MORGAN AND MORECAMBE OFFSHORE WIND FARMS: TRANSMISSION ASSETS

Technical Note: Landscape and Design Matters

Deadline: Deadline 3
7 July 2025

Document reference: S_D3_7

**Figure 1.6: Outline management of PROW within the Onshore Order Limits (Sheet 3)**

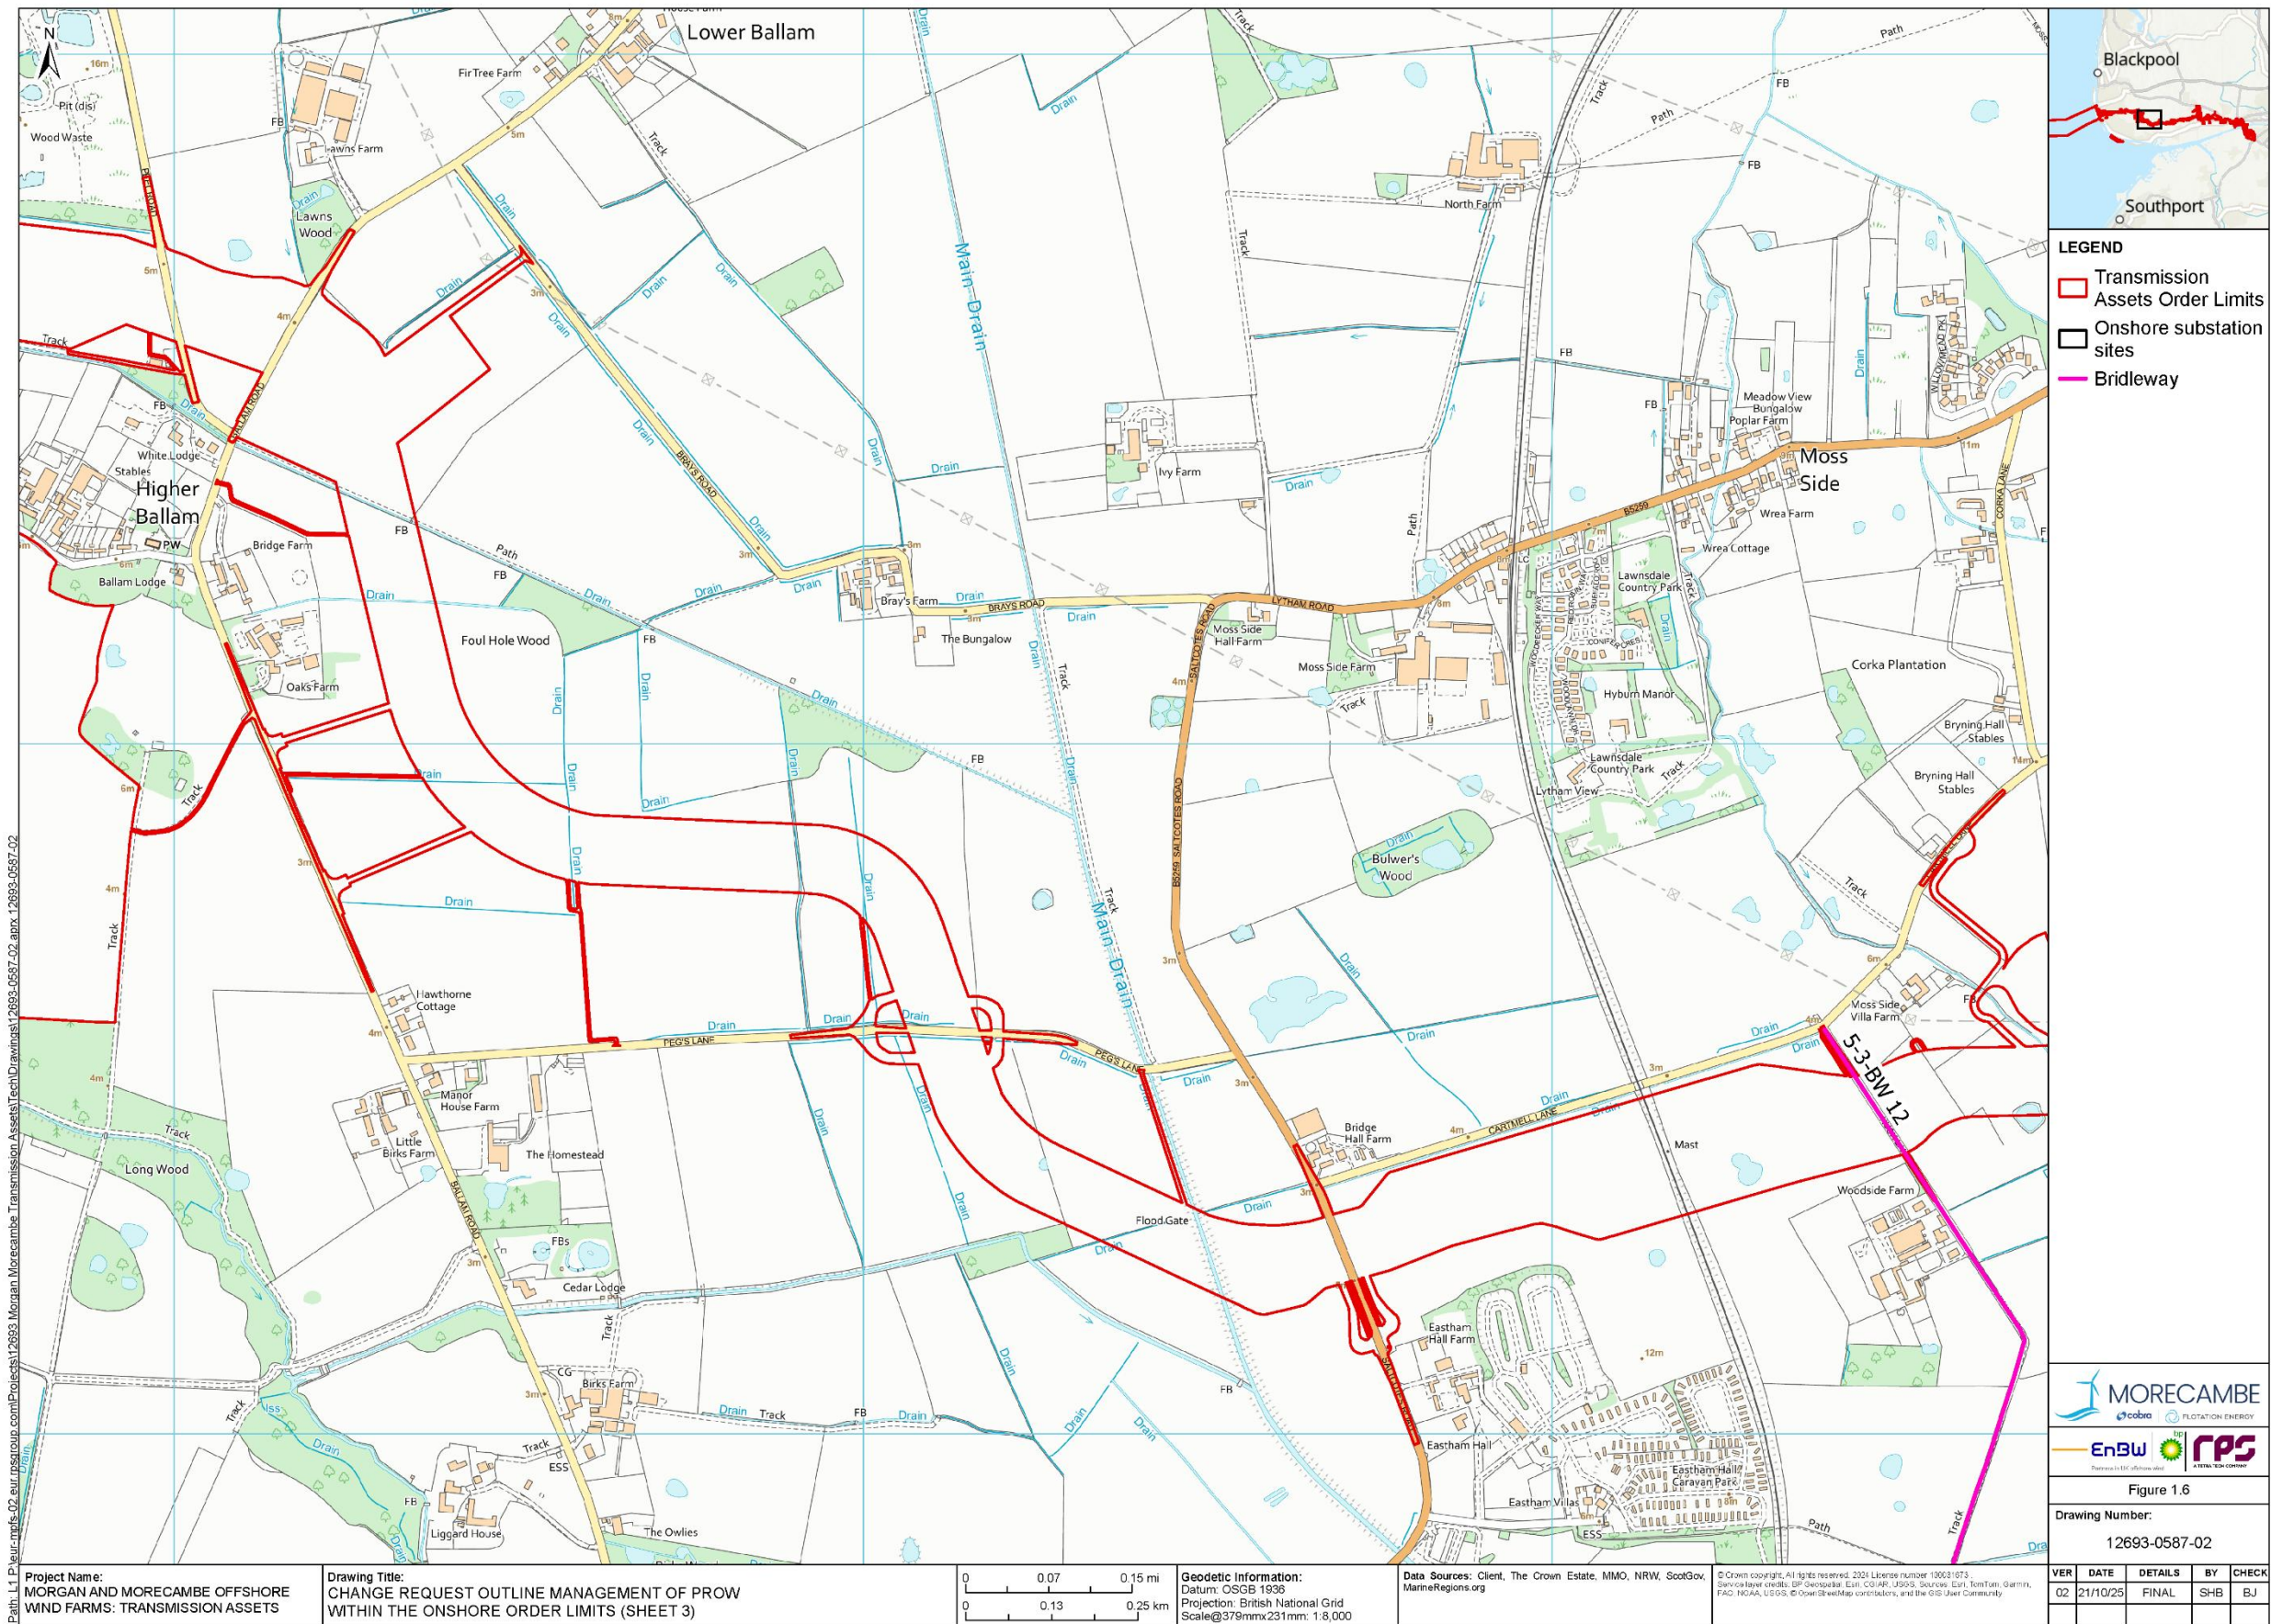
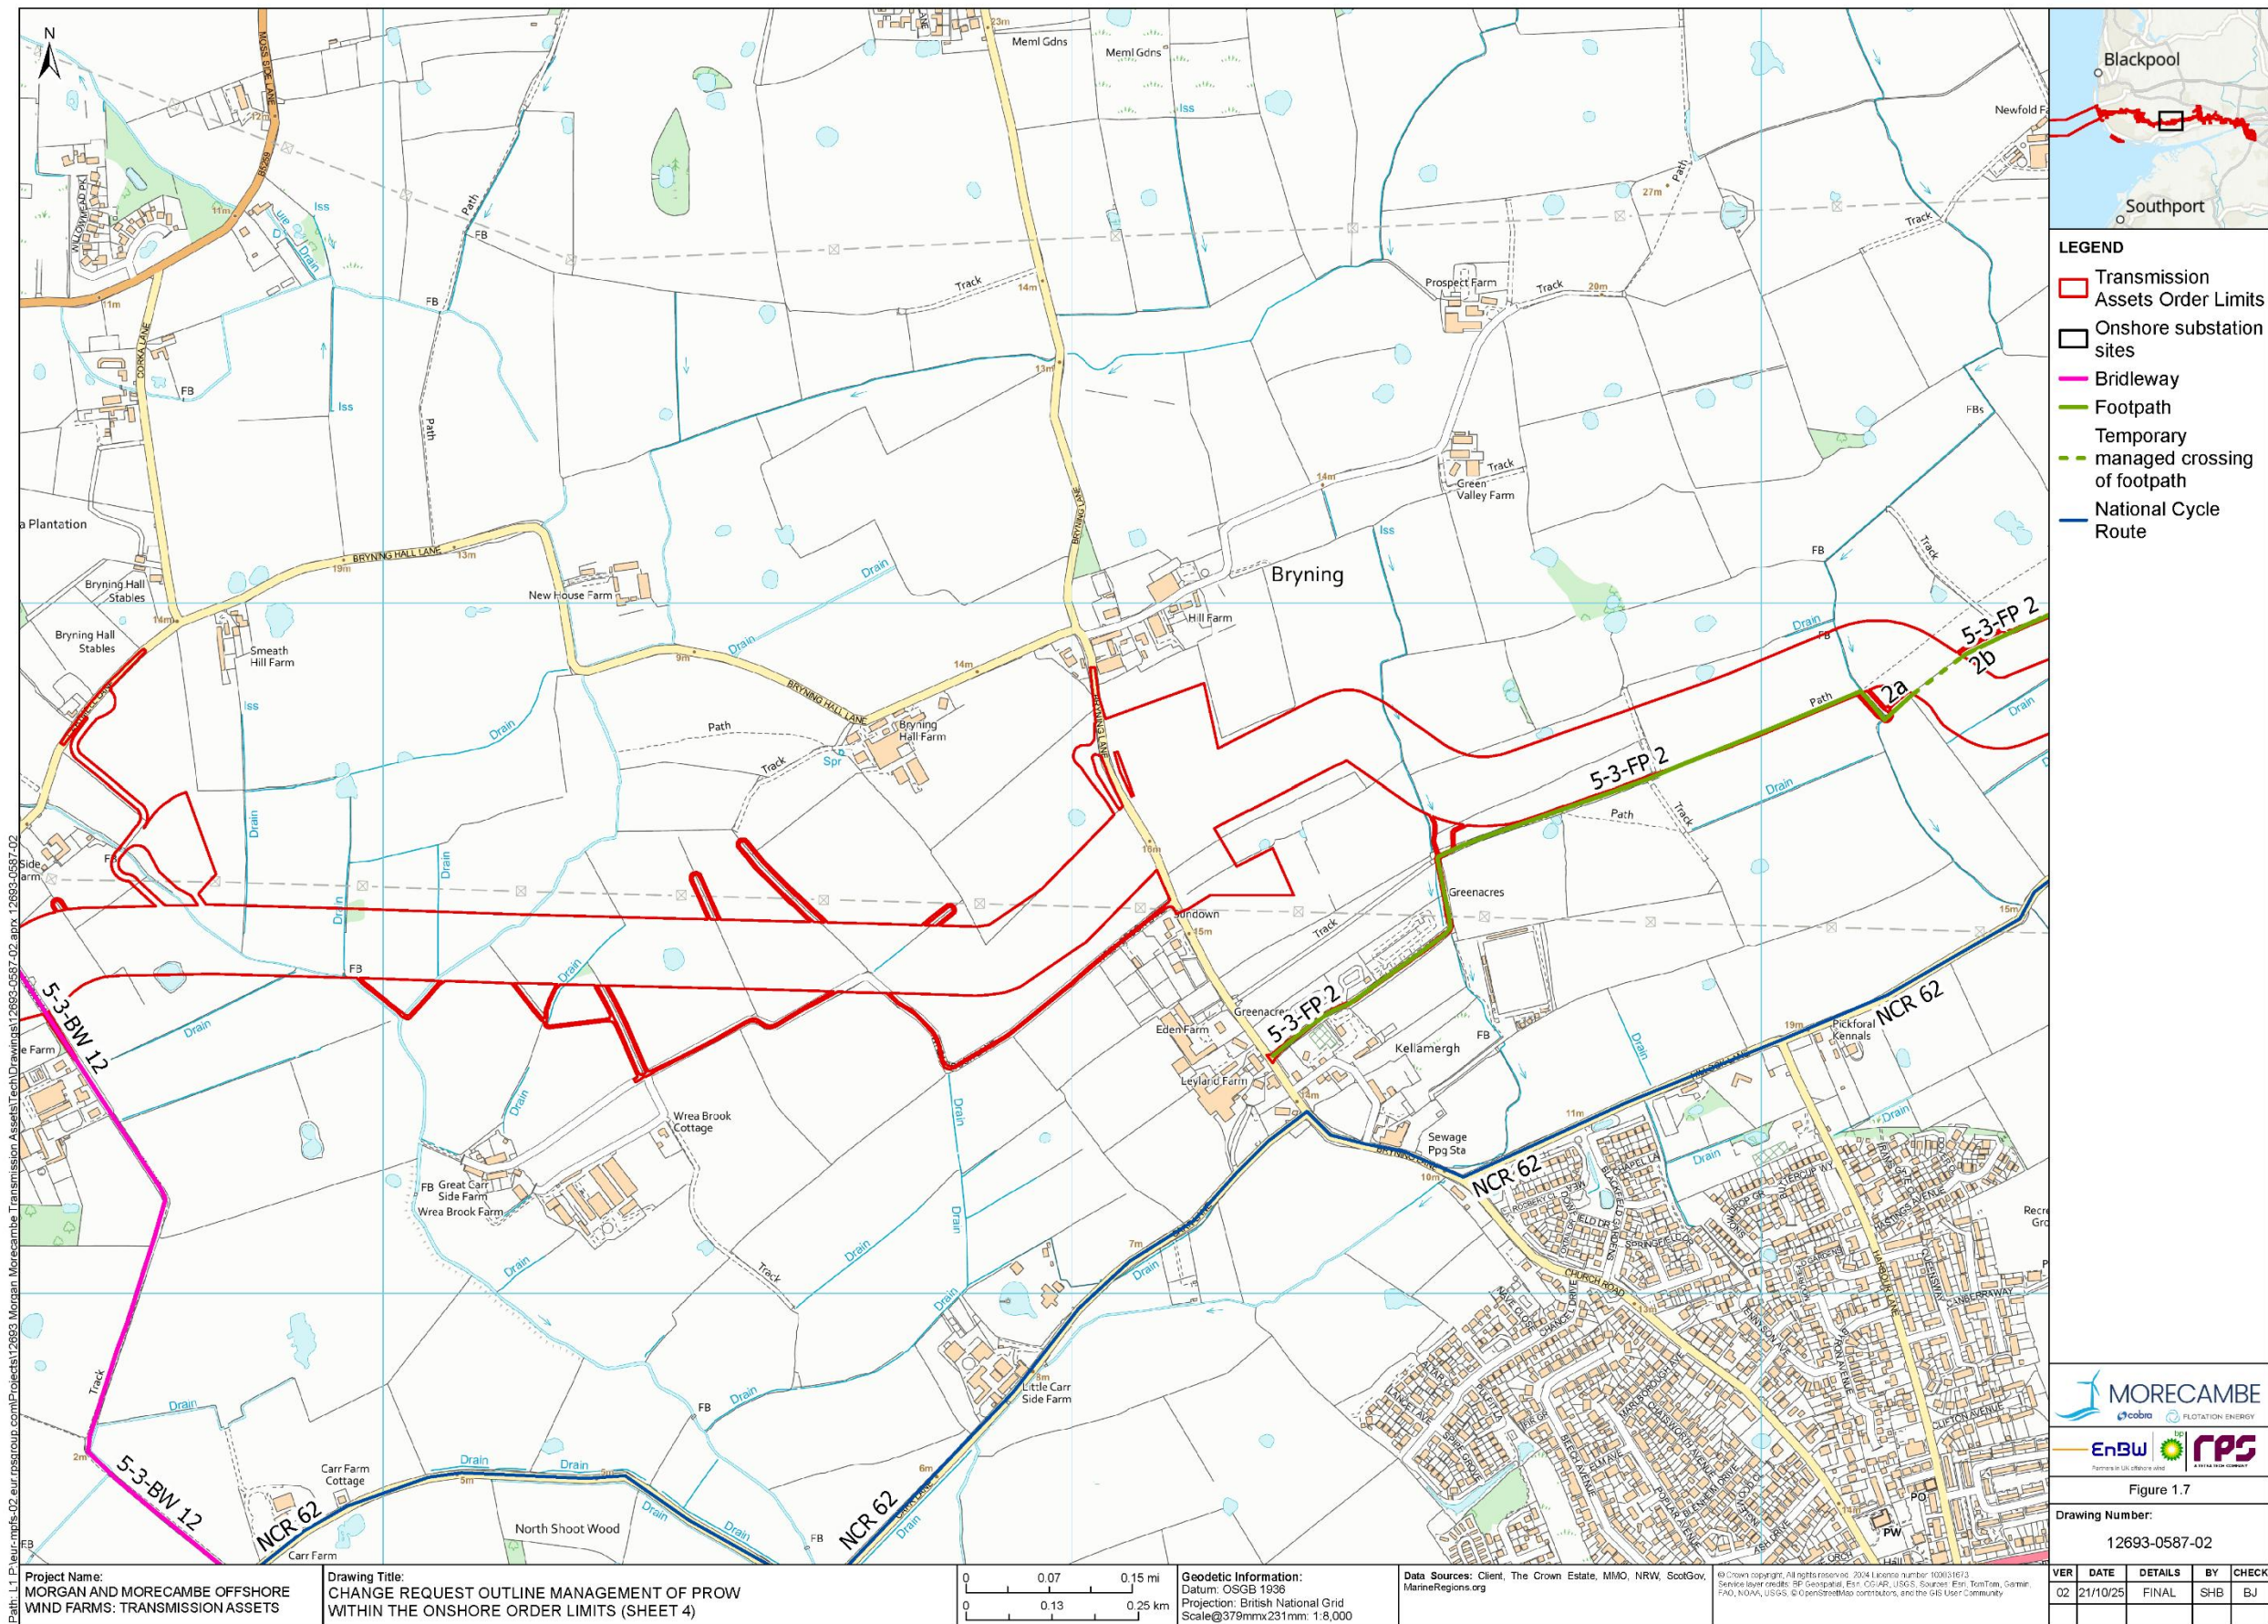
- 1.2.1.1 LCC LIR comment **REP1-085 7.49** raises concerns about the lack of detail in relation to the reinstatement of Public Rights of Way (PRoW) affected by the transmission works, particularly in relation to surfacing materials and demarcation, and requests clarity on how these will be restored, including features such as gates and signage.

- 1.2.1.2 The Applicants refer to the Outline Public Rights of Way Management Plan (AS-048), secured through Requirement 8 of the draft DCO (REP2-004) (dDCO). This Requirement outlines the principles for managing PRoWs during construction, making clear that detailed PRoW Management Plans will be developed and approved by relevant planning authorities, in consultation with stakeholders, before works commence. These plans will include specific information on surfacing and design, as confirmed in Section 1.5.8 of the Outline Public Rights of Way Management Plan (AS-048).
